**Consultation Response from KC,  
Lead Local Flood Authority**

**2023/93667 Storthes Hall Student Village, Storthes Hall Lane, Kirkburton, Huddersfield, HD8  
0WA**

**Outline application for demolition of buildings and erection of residential development (up to  
261 dwellings), redevelopment of Lodge Cottage for residential use and associated works**

**Date Responded: 6<sup>th</sup> February 2024**

Site Layout Plan with Tree Root Protection Areas - Scale 1:1000

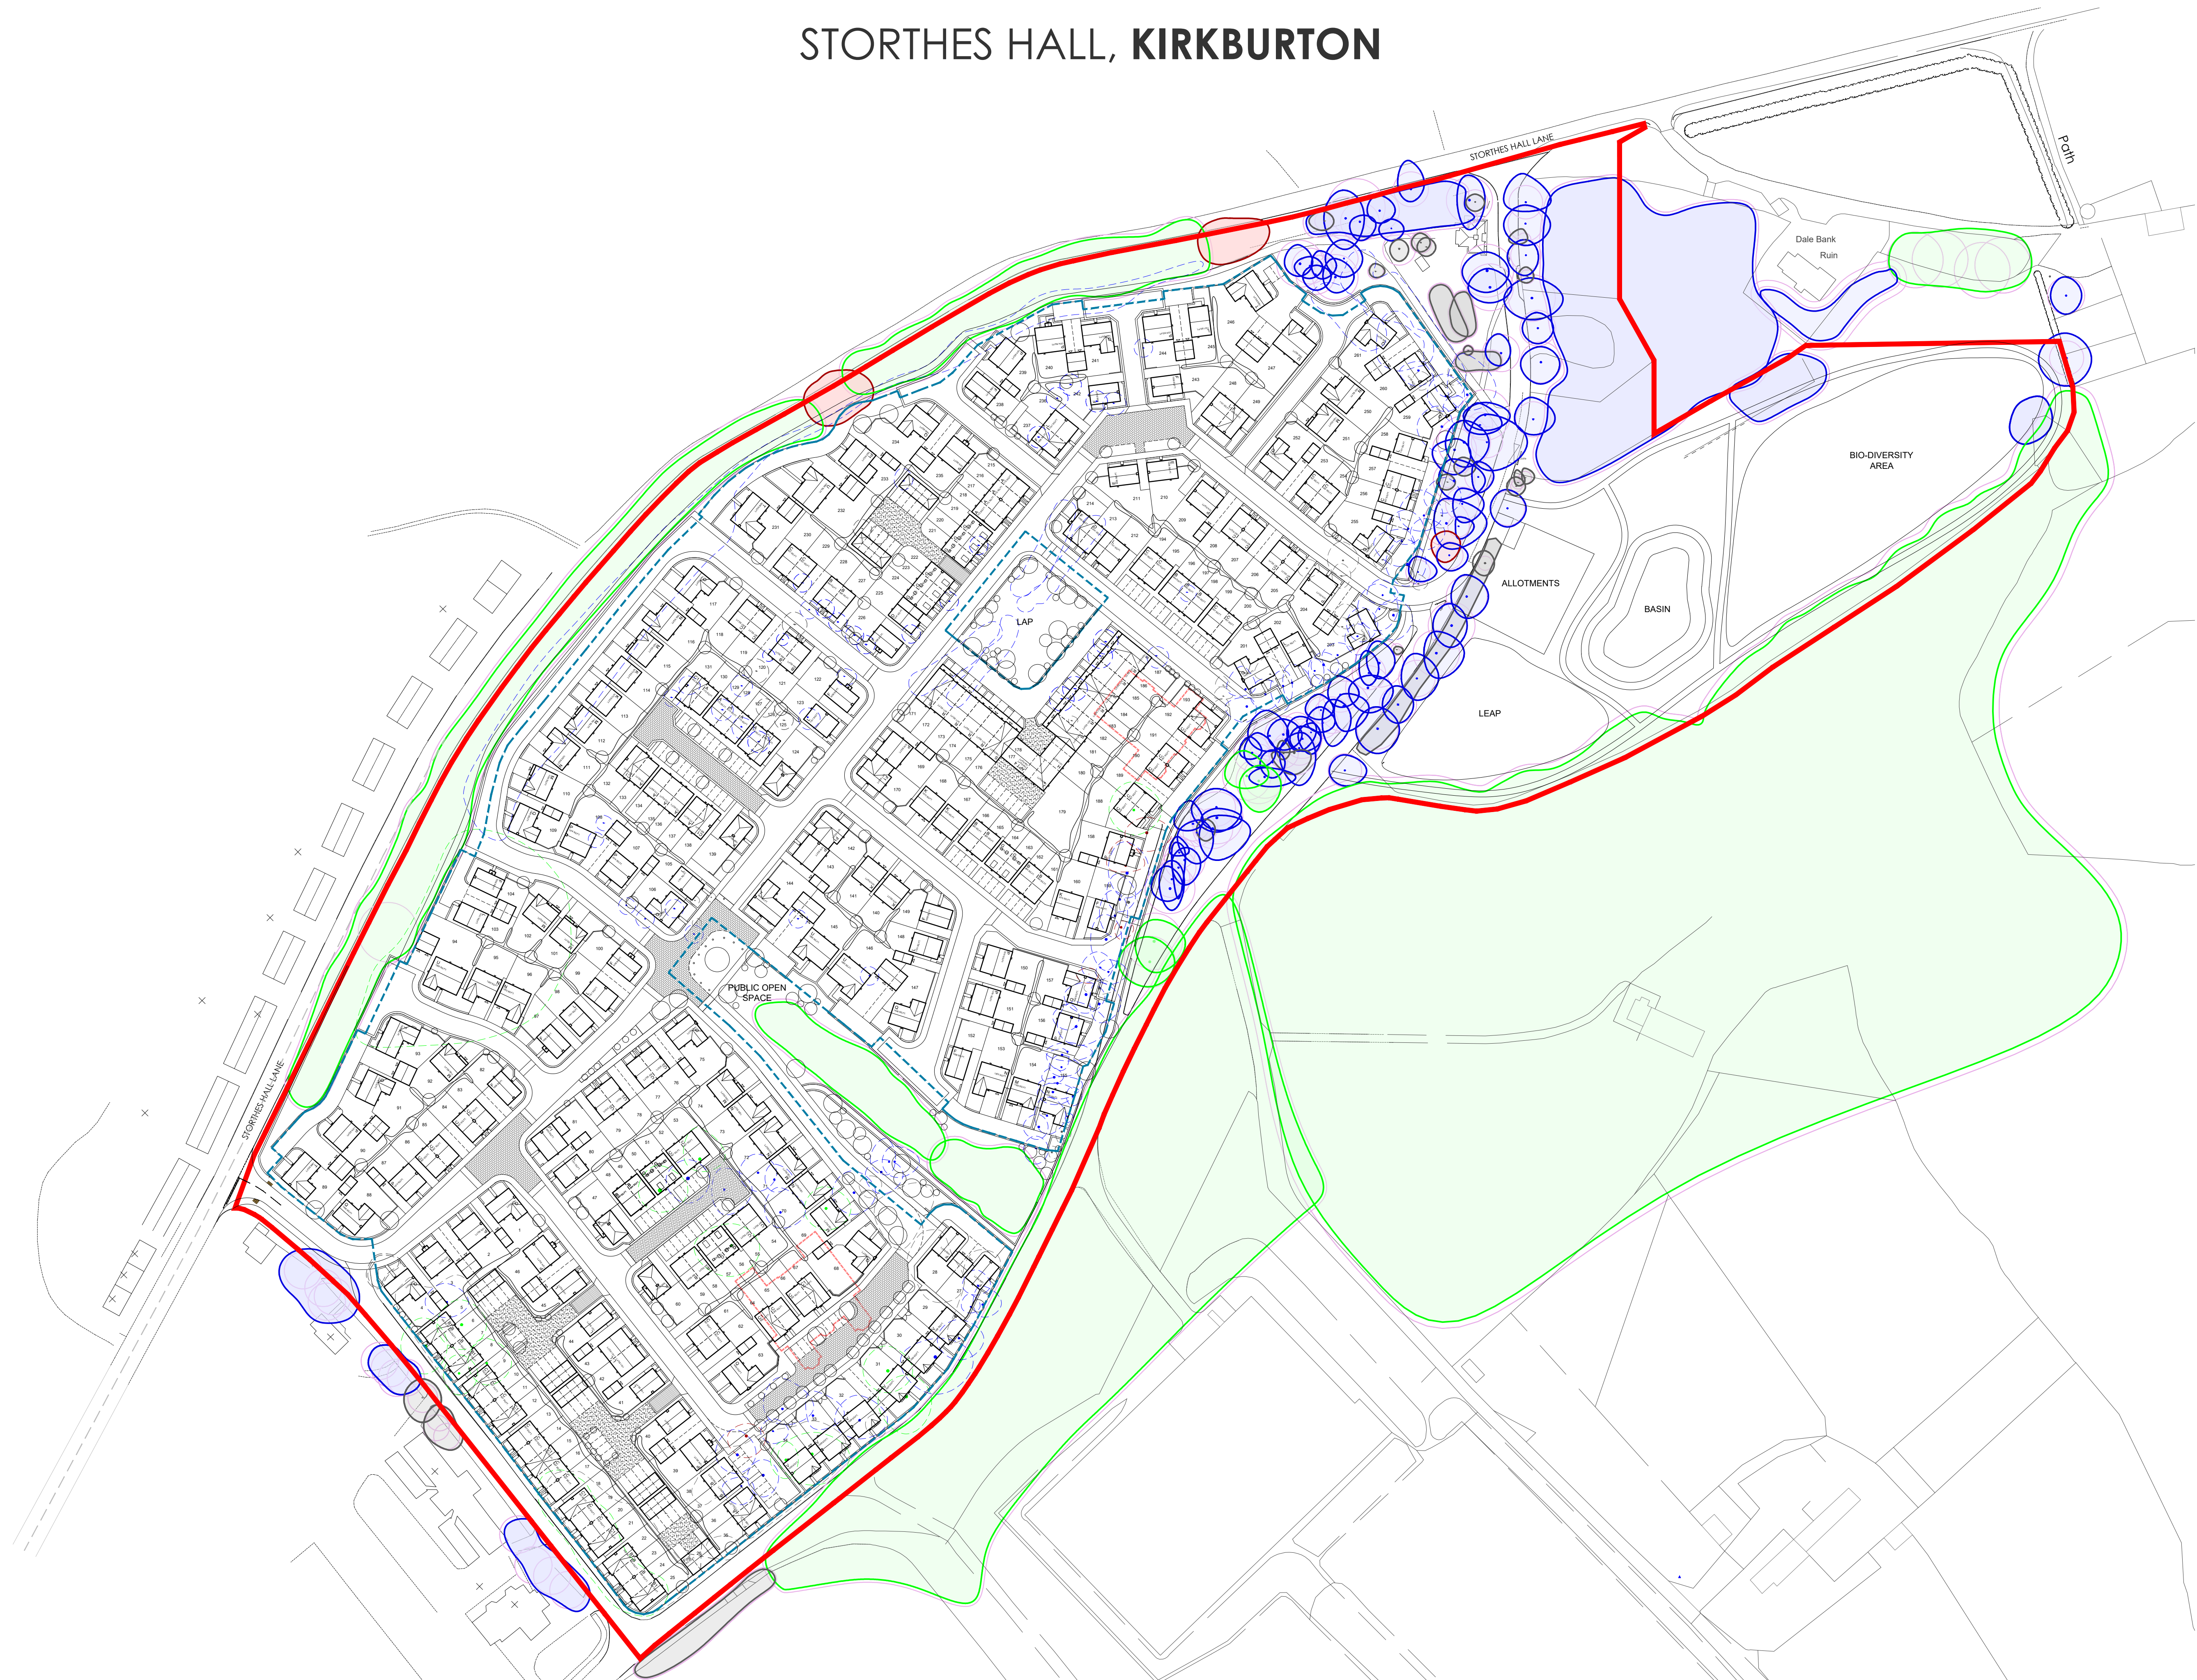
- As assessment of proposed drainage and how it may be affected by or affect landscaping plans issued, e.g. tree planting, tree root investigations areas, tree to remain.
